Appendix 12

Road Safety Audit, Designer's Response and Road Safety Audit Addendum

Road Safety Audit – Summer Lane, Pagham

Site: Proposed accesses to residential development

Proposed Site Access Arrangement (HTp/2607/01 Sheet 1 to 2 of 2)

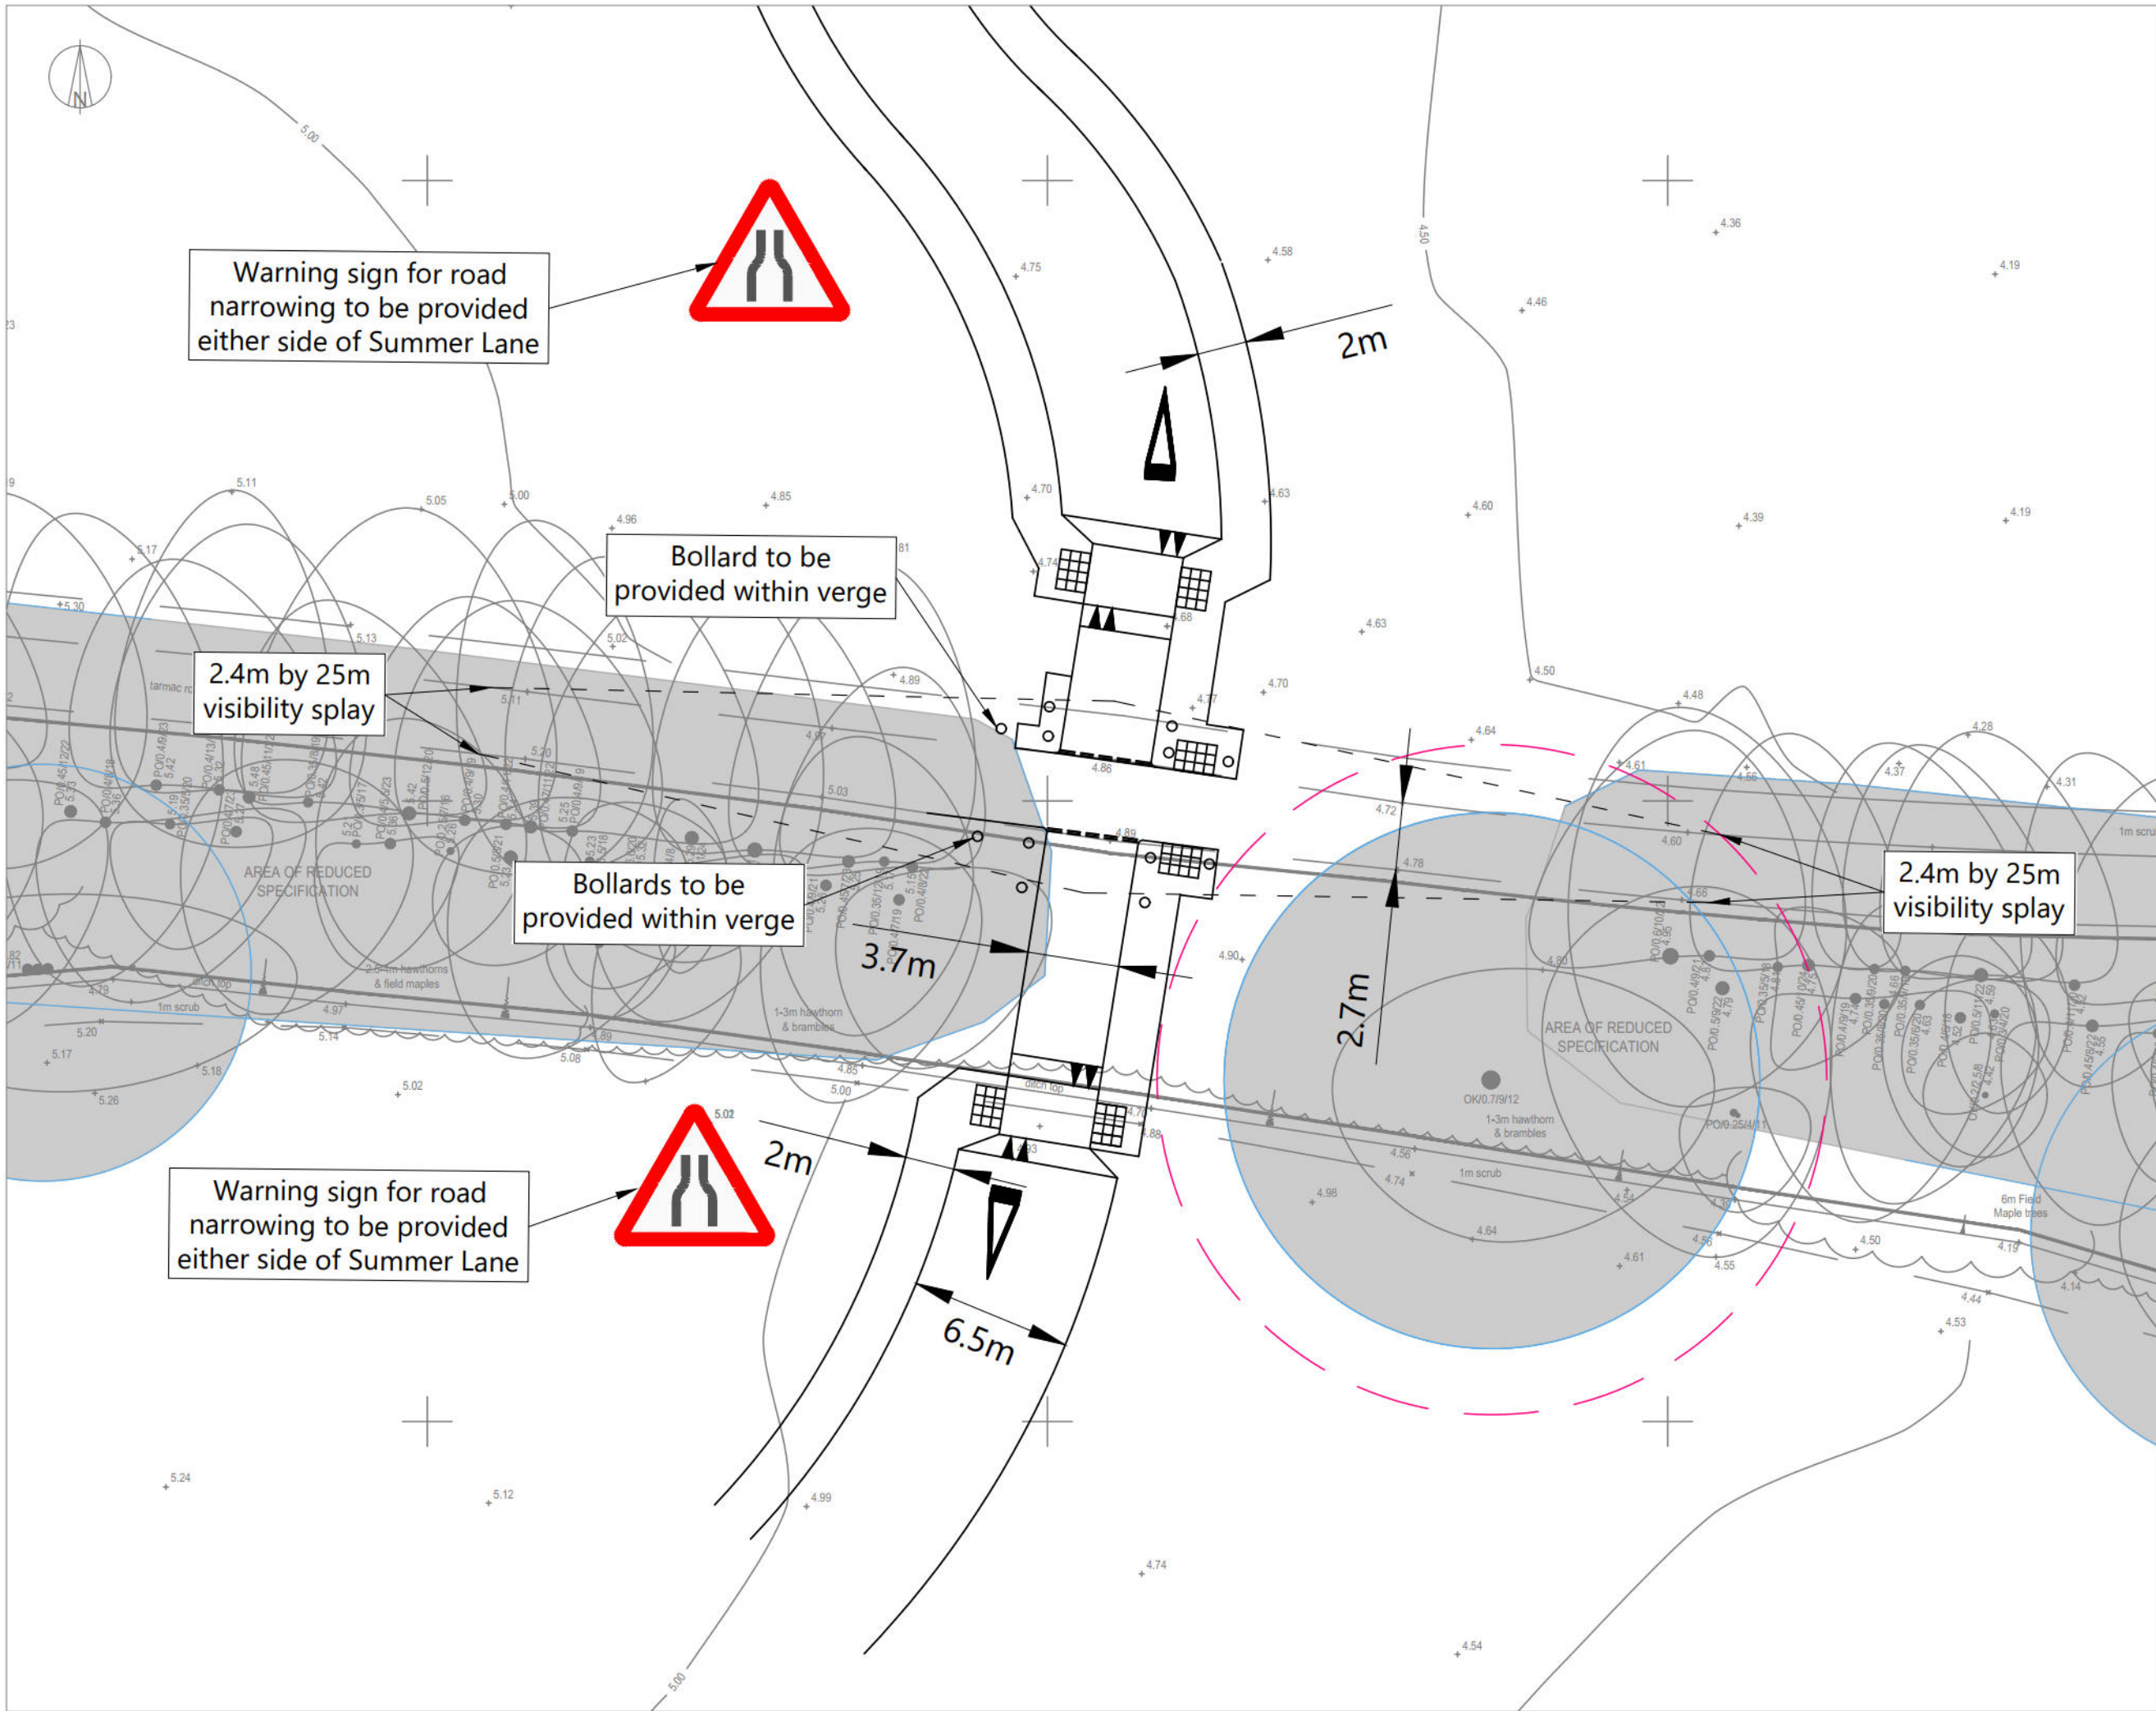
Visually impaired pedestrians accessing Summer Lane from the new development may not be aware of the proposed steps. This may lead to pedestrian trips and falls.

Recommendation – Implement corduroy tactile paving to highlight the steps for visually impaired users.

Without adequate street lighting, the proposed speed table crossing the junction may cause loss of control collisions in the hours of darkness if drivers are not aware of the changes in levels.

Recommendation – Ensure adequate lighting and correct signage is used on the approach to the proposed junction.

The proposed tactile paving layout at the junction may cause confusion for visually impaired pedestrians. As currently designed, the tactile paving directs users across both the northern access and the east/west carriageway. However, the east/west carriageway does not include a corresponding southern crossing point, which may result in visually impaired pedestrians being guided into the carriageway without a safe exit or refuge. This could increase the potential risk of conflict with vehicular traffic.

Recommendation – Ensure that the tactile paving across the northern access road do not direct pedestrians into the east/west carriageway.

The proposed east/west access road crosses an exposed culvert twice. No protective fencing has been indicated on the scheme drawings. A vehicle losing control and leaving the carriageway, or any pedestrians falling into the culvert, will be at risk of injury.

Recommendation – Ensure adequate fencing is implemented within the design to highlight the risk and diminish the risk of pedestrian falls.

2.3.1 Location – Proposed junction between northern access road and east/west access road Summary – Risk of loss of control collisions Without adequate street lighting, the proposed speed table crossing the junction may cause loss of control collisions in the hours of darkness if drivers are not aware of the changes in levels.	Ensure adequate lighting and correct signage is used on the approach to the proposed junction.	Agreed Lighting and signage will be considered as part of the detailed design and information will form part of the detailed design package provided to the audit team at Stage 2

2.3.2 Location – Proposed junction between northern access road and east/west access road Summary – Risk of pedestrian conflict with vehicles The proposed tactile paving layout at the junction may cause confusion for visually impaired pedestrians. As currently designed, the tactile paving directs users across both the northern access and the east/west carriageway. However, the east/west carriageway does not include a corresponding southern crossing point, which may result in visually impaired pedestrians being guided into the carriageway without a safe exit or refuge. This could increase the potential risk of conflict with vehicular traffic.	Ensure that the tactile paving across the northern access road do not direct pedestrians into the east/west carriageway.	Noted It will be ensured at Stage 2 that the Tactile paving will not direct pedestrians into the east/west carriageway		
--	---	---	--	--

NOTES:
© Crown copyright and database rights 2026 OS Licence AC0000855217.
Drawing based on GTA plan Link Road between Phases Site Levels & Contours ref 13226_1855_P2, received 12/11/25
and HTP Access Arrangement Drawing HTP/2607/01 Sheet 1, dated 02/02/2026

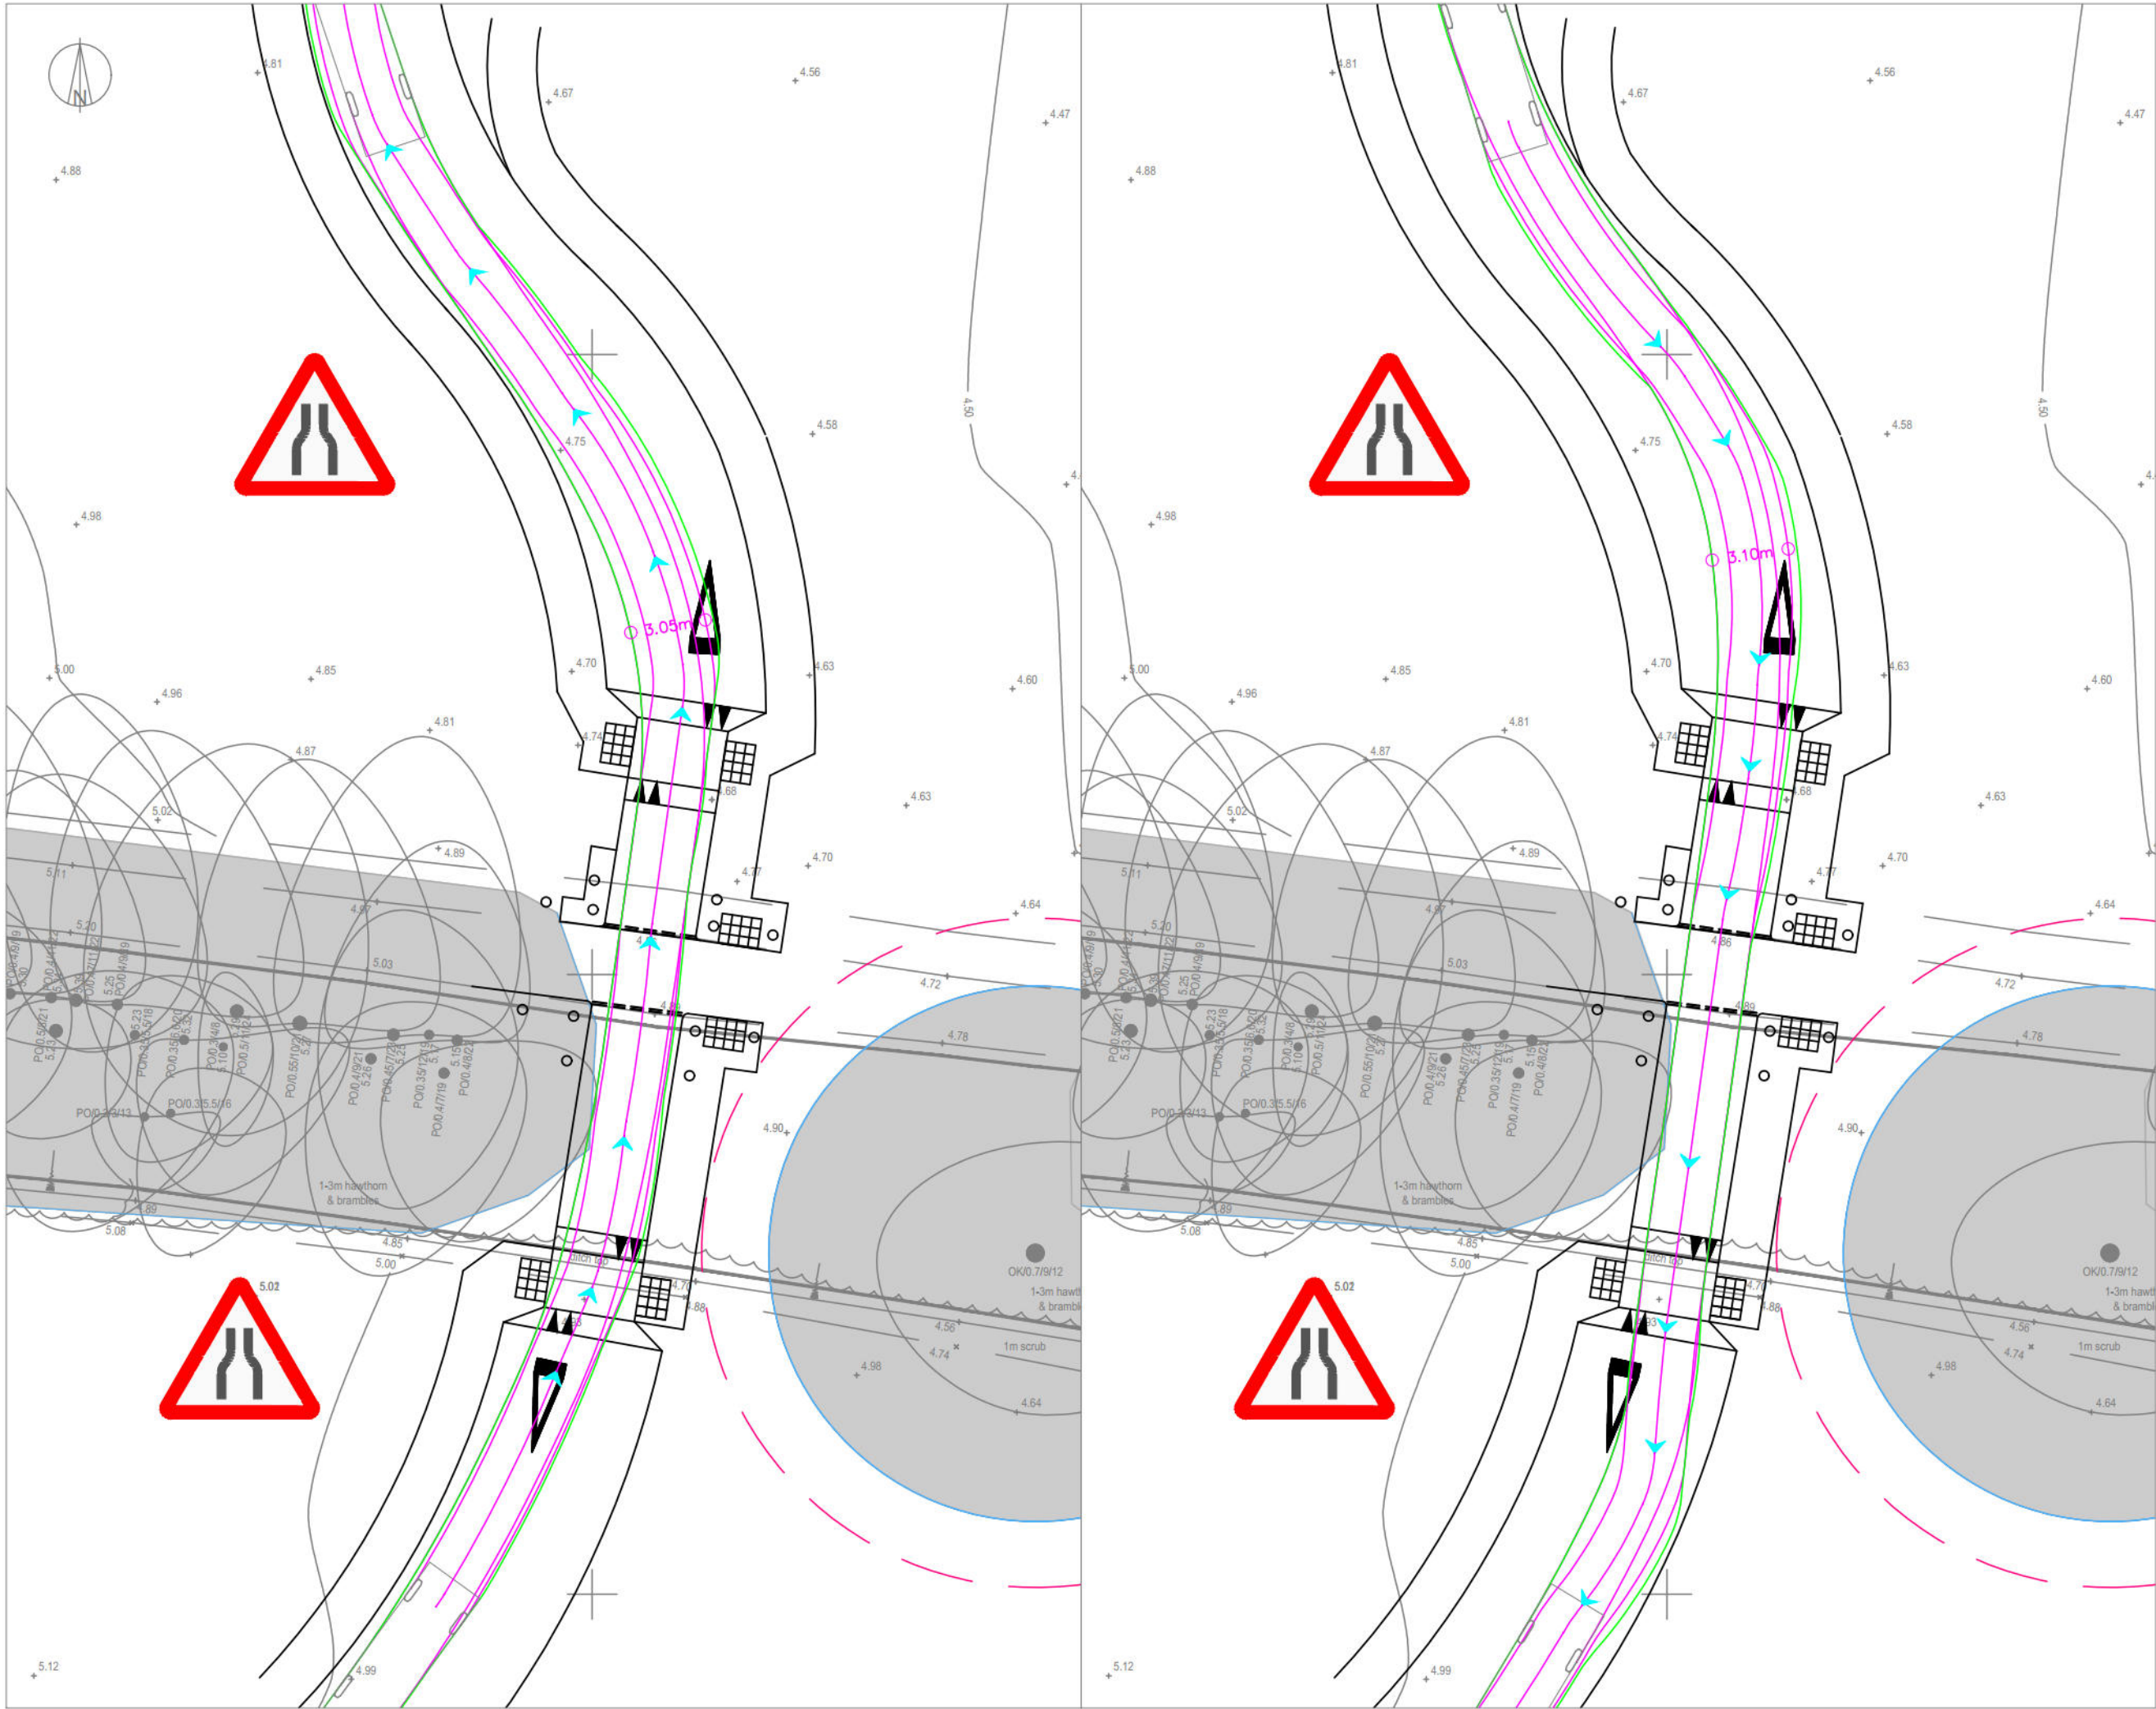
The proposed carriageway narrowing that links the two proposed estates across Summer Lane is controlled by Give Ways at the junction with Summer Lane. Drivers travelling in opposing directions may not fully understand nor appreciate the length of the narrowing and attempt to pass each other where space does not permit such a manoeuvre, which may lead to head on collisions and damage only incidents, or vehicles mounting the footway.

Recommendation – Investigate whether a formal priority system may work in this location

While it is acknowledged that a turning manoeuvre is not possible from the proposed access narrowing across Summer Lane, without a formal restriction in operation vehicles following satellite navigation systems may attempt the manoeuvre, which will lead to street furniture and vehicles being damaged.

Recommendation – Implement a No Left/Right Turn restriction where the proposed access road crosses Summer Lane, from all directions.

RSA problem	RSA recommendation	Design organisation response	Overseeing Organisation response	Agreed RSA action
2.2.1 Location – Proposed narrowed section across Summer Lane Summary – Risk of head on and damage only collisions The proposed carriageway narrowing that links the two proposed estates across Summer Lane is controlled by Give Ways at the junction with Summer Lane. Drivers travelling in opposing directions may not fully understand nor appreciate the length of the narrowing and attempt to pass each other where space does not permit such a manoeuvre, which may lead to head on collisions and damage only incidents, or vehicles mounting the footway.	Investigate whether a formal priority system may work in this location	Noted It has been investigated as to whether a formal priority system would work in this location, however, it is not considered that it would be appropriate to incorporate a formal priority system in this location, given that we are to maintain priority for the PRoW on Summer Lane, as requested by WSCC Highways as part of the pre-application discussions. Furthermore, the design will result in vehicles being cautious when crossing Summer Lane

2.2.2 Location – Proposed narrowed section across Summer Lane Summary – Risk of collisions with street furniture While it is acknowledged that a turning manoeuvre is not possible from the proposed access narrowing across Summer Lane, without a formal restriction in operation vehicles following satellite navigation systems may attempt the manoeuvre, which will lead to street furniture and vehicles being damaged.	Implement a No Left/Right Turn restriction where the proposed access road crosses Summer Lane, from all directions.	Agree and Noted The implementation of signage will be addressed as part of the Stage 2 Road Safety Audit. In any event, it will be very apparent that the junction is crossing a PRoW that vehicles will not be able to turn onto Summer Lane, and therefore additional signage may not be required.
